Our Case Number: ACP-323851-25

Re: Proposed construction of the Celbridge Hazelhatch Mobility Corridor
Celbridge Town, County Kildare

RE: Celbridge Hazelhatch Mobility Corridor Application, Case Ref: JP09.323851

Status: A1

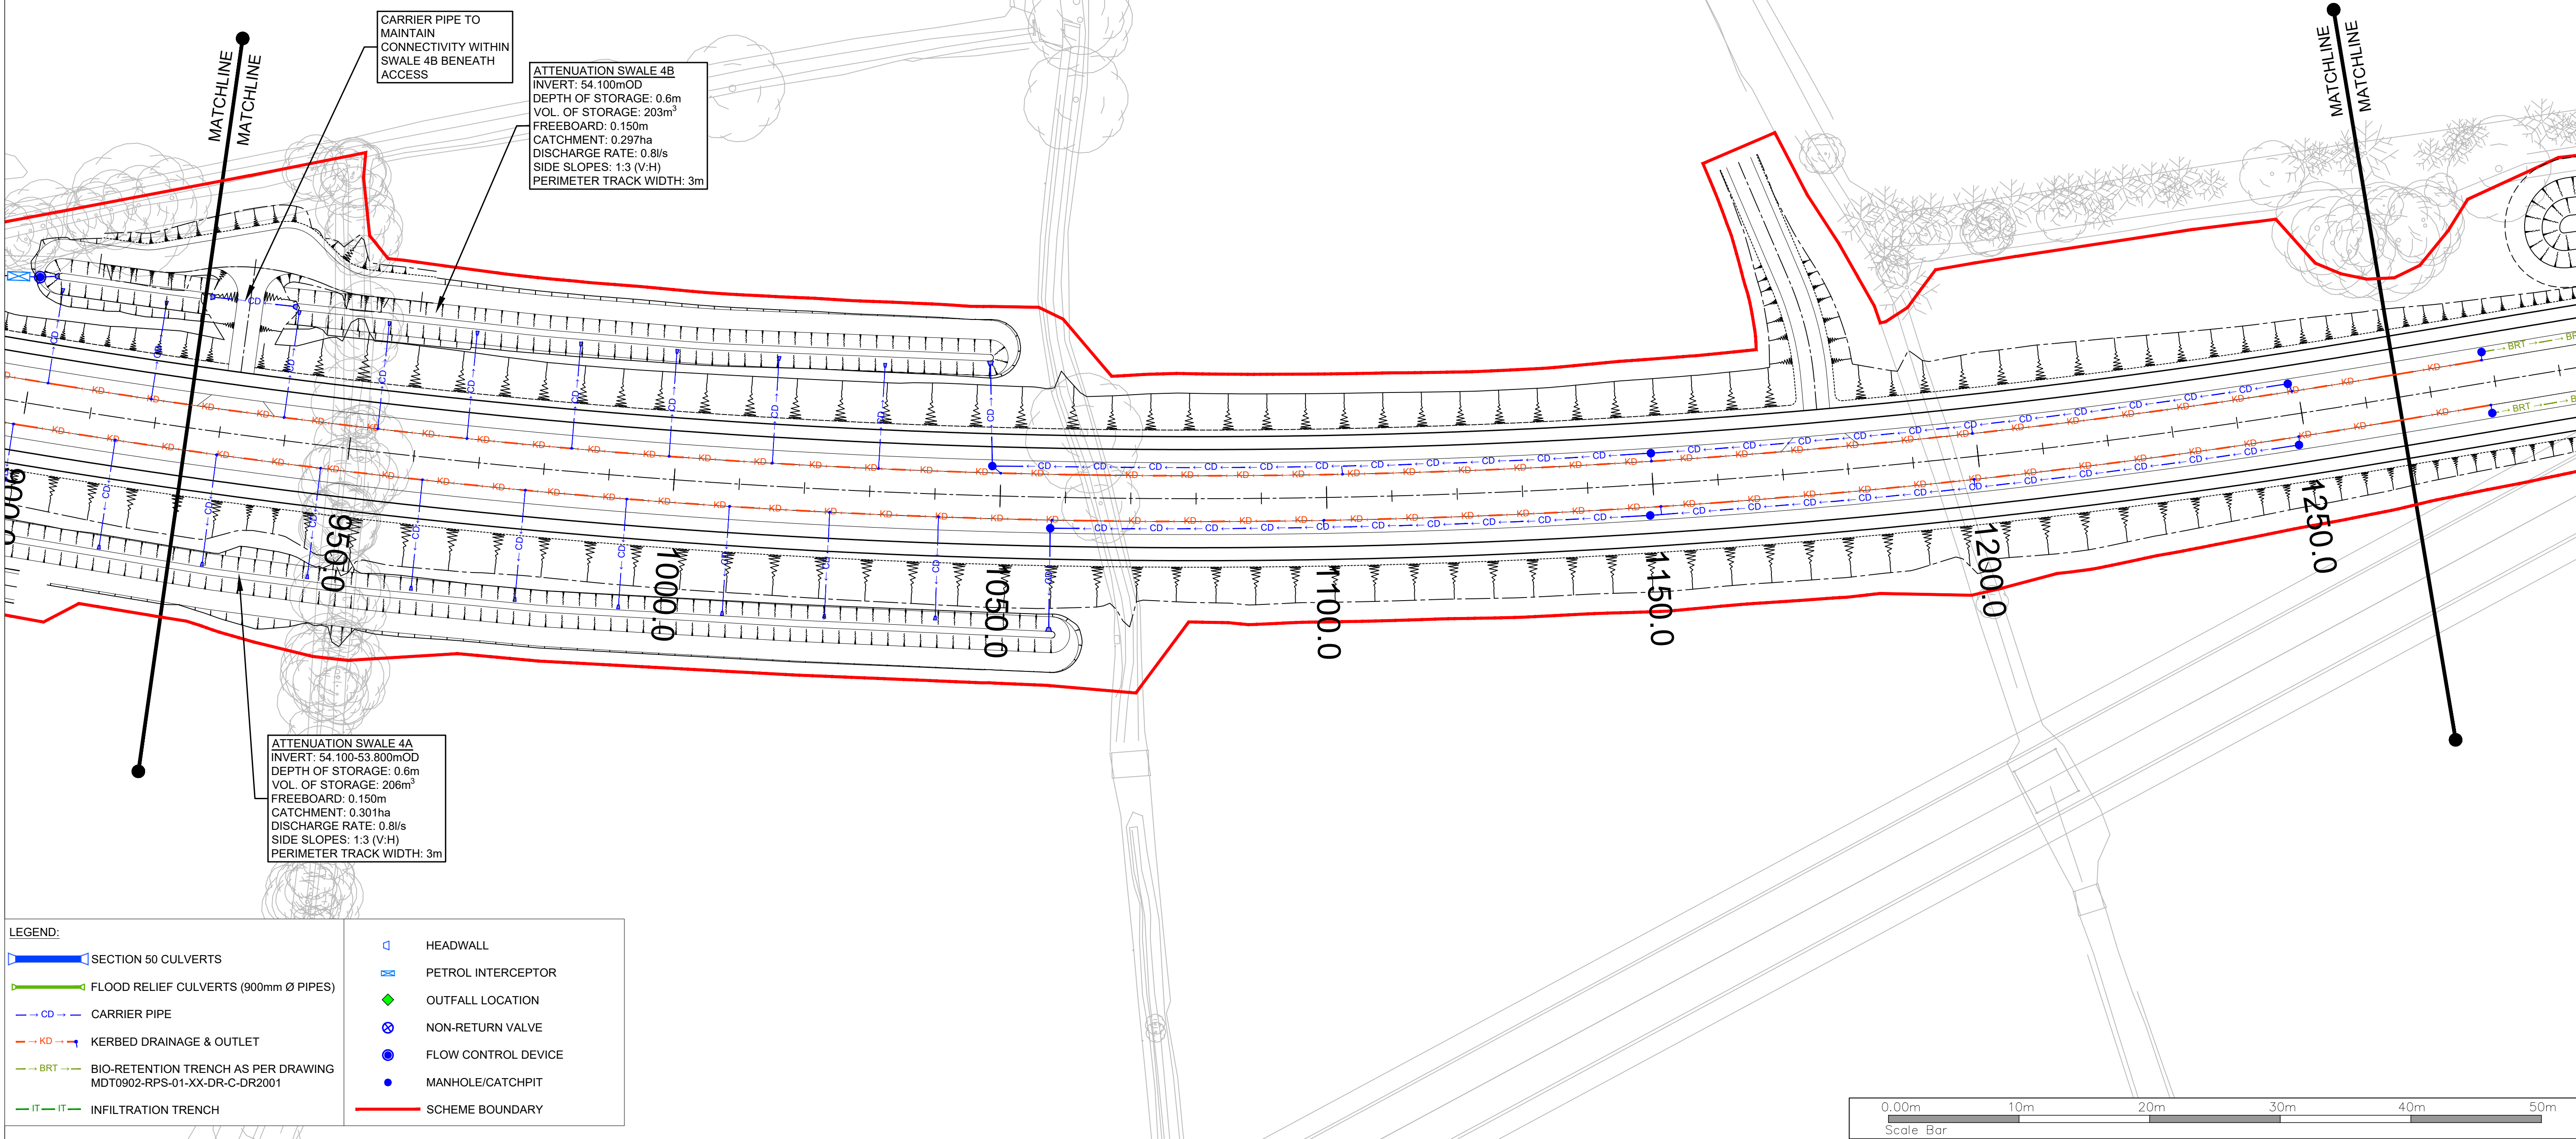
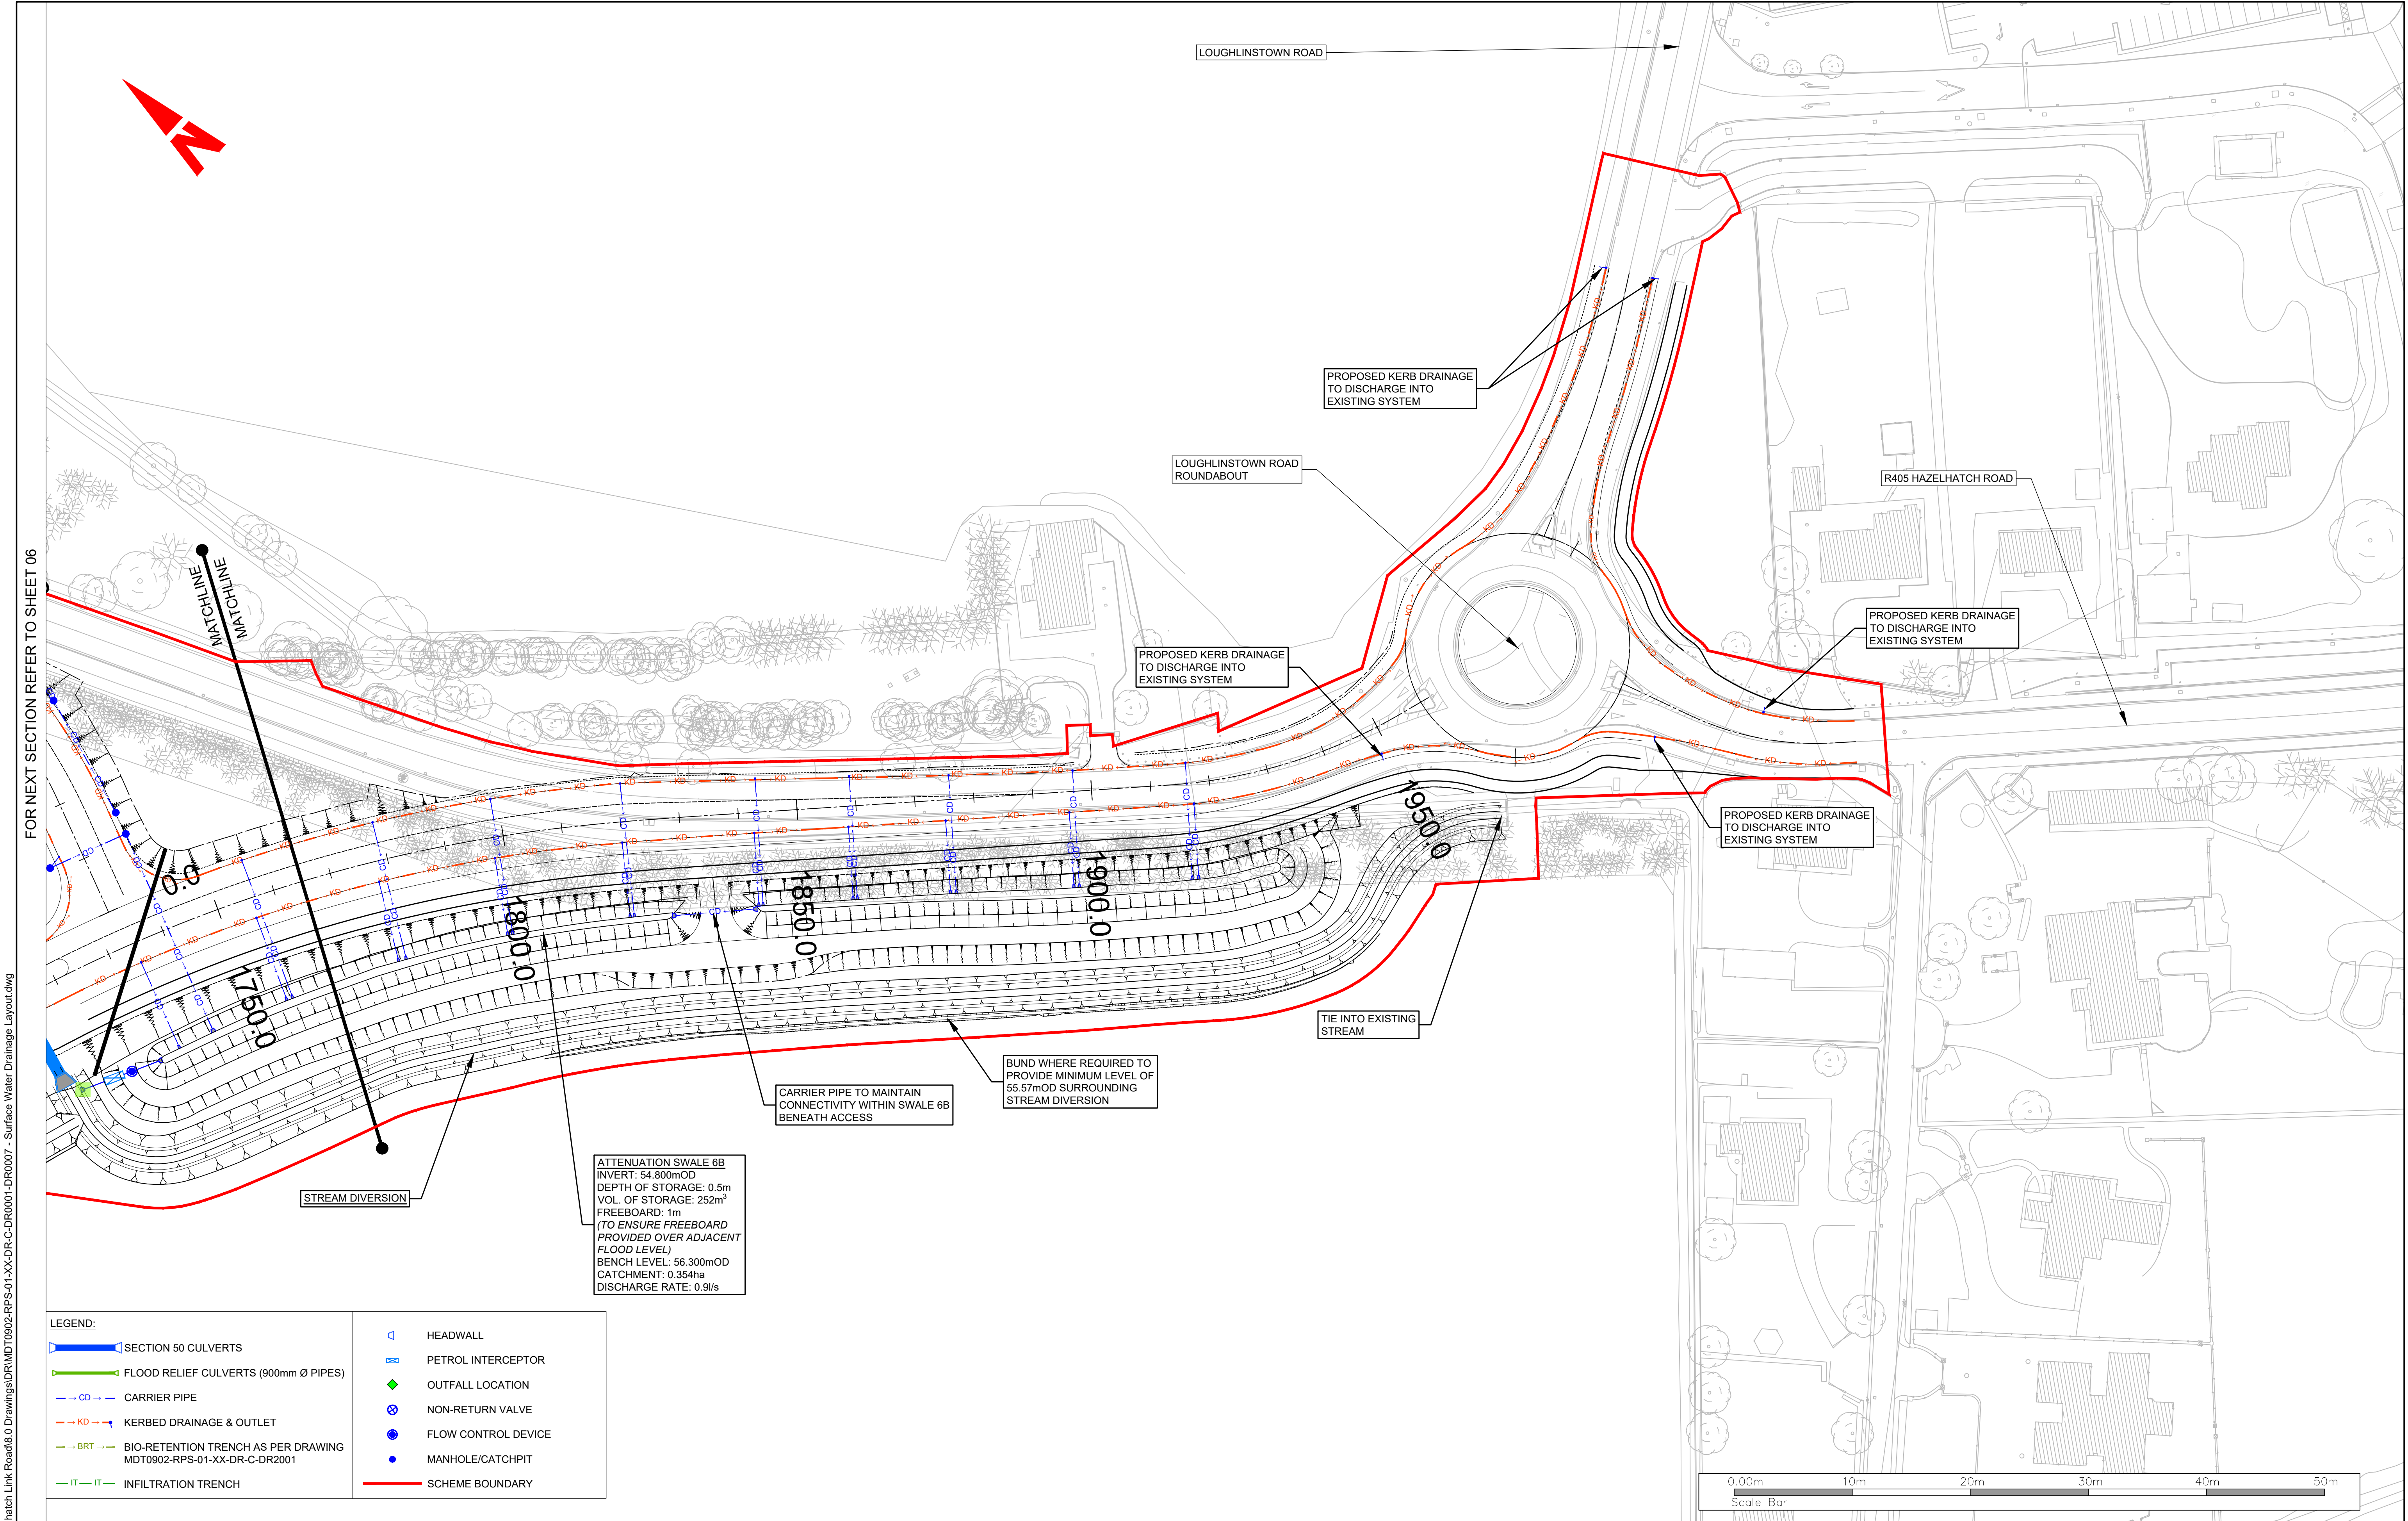
It is our opinion that the stormwater management strategy for the Mobility Corridor, incorporating linear stormwater channels and storage features, should be reviewed so as not to impact adjacent proper development. The current design has swales on both sides of the corridor. This is not conducive to a streetscape and should be reconsidered.

There are a number of attenuation basins and swales located on both sides of the Mobility Corridor. While it is acknowledged that these features are necessary for the construction of the Mobility Corridor, it is suggested that their layout and extent be reviewed in light of their potential impact on future residential development frontages. As currently proposed, the location of the basins and swales would push back potential residential building lines from the road edge, in some instances by up to 20m.

In this context, the current extent and positioning of the proposed attenuation basins and swales along the Mobility Corridor may conflict with DMURS principles by increasing the separation between the carriageway and future development plots. This could result in recessed building lines, reduced enclosure and a diminished opportunity to deliver active frontages along the corridor. A review of the layout, scale, and continuity of these features is therefore suggested to ensure alignment with DMURS objectives and to support the creation of a legible street that balances movement with placemaking.
